## Fire Marshal Division

**RE: Lafayette Elementary School**  
**108 Lafayette School Rd.**  
**Kipling, NC 27543**

**Re: Application Number – FMFW1905-0004**

ANSUL R-102
3.0 GALLON
UL 300
6 FLOW POINTS

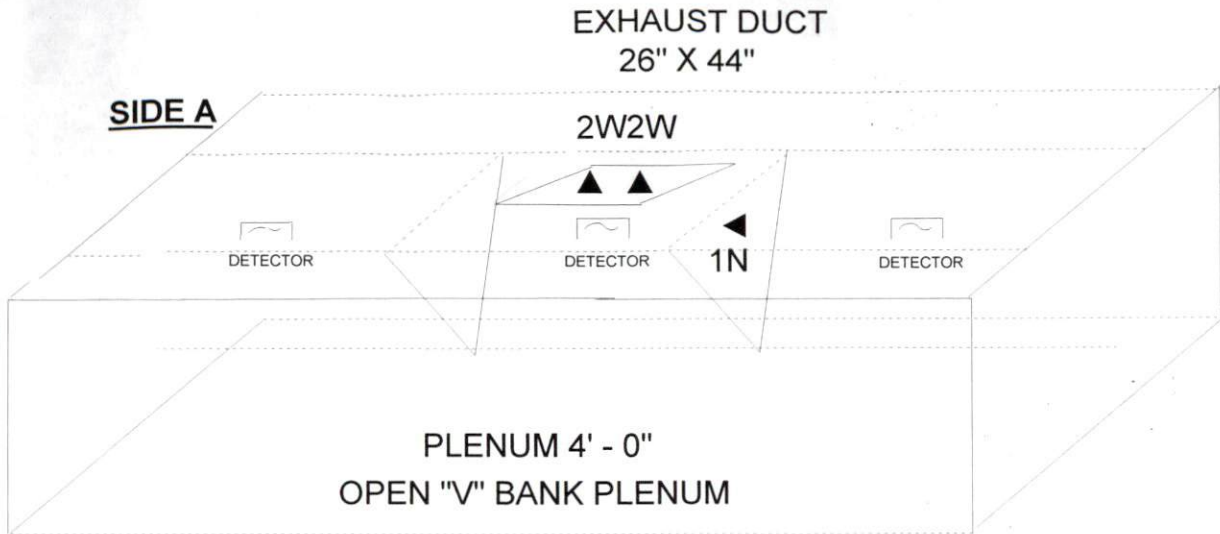
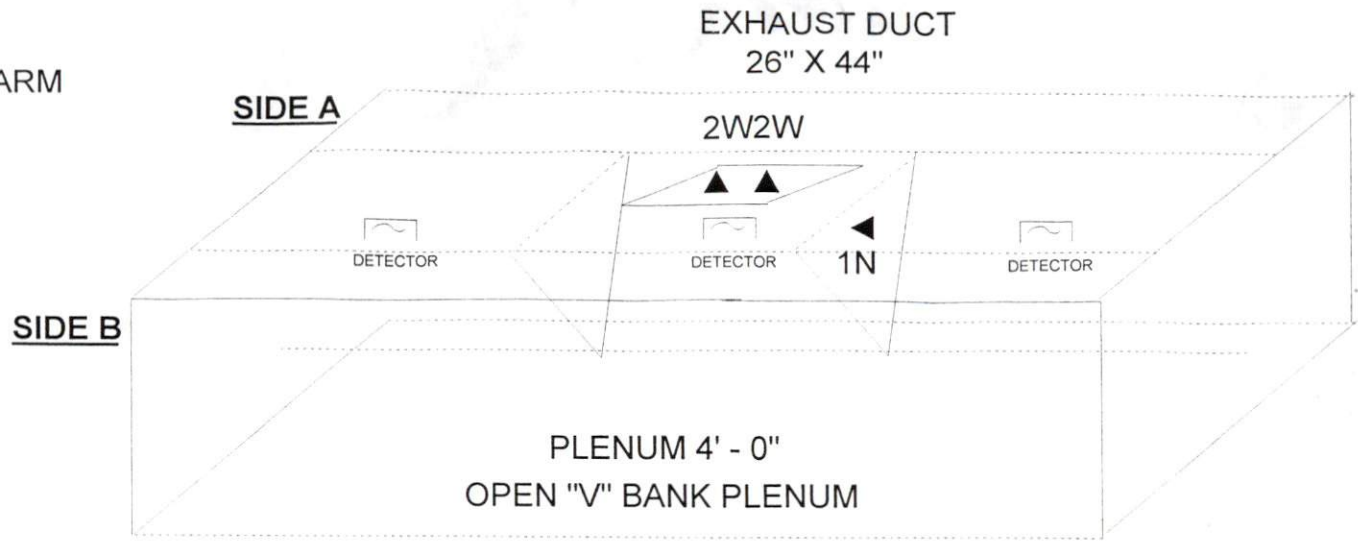
- **Commercial cooking equipment.**
  - A multi-purpose ABC type extinguisher (minimum 2A-10BC) shall be provided and mounted within 5ft. of the finished floor with a maximum travel distance of 75 ft.
  - Portable fire extinguishers shall be provided within a 30-foot (9144 mm) travel distance of commercial-type cooking equipment. Cooking equipment involving vegetable or animal oils and fats shall be protected by a Class K rated portable extinguisher.
- **Acceptance Test**
  - An acceptance test will be conducted by the Fire Marshal's office once system has been installed and pre-tested.
  - Installation shall be per architectural and system submittals and compliant with NFPA-17A.
- **Manual system operation**
  - A manual actuation device shall be located at or near a means of egress from the cooking area, a minimum of 10 feet (3048 mm) and a maximum

of 20 feet (6096 mm) from the kitchen exhaust system. The manual actuation device shall be located a minimum of 4.5 feet (1372 mm) and a maximum of 5 feet (1524 mm) above the floor. The manual actuation shall require a maximum force of 40 pounds (178 N) and a maximum movement of 14 inches (356 mm) to actuate the fire suppression system.

- The actuation of the fire suppression system shall automatically shut down the fuel or electrical power supply to the cooking equipment. The fuel and electrical supply reset shall be manual.

- Where a building fire alarm system is installed, automatic fire-extinguishing systems shall be monitored by the building fire alarm system in accordance with NFPA 72.
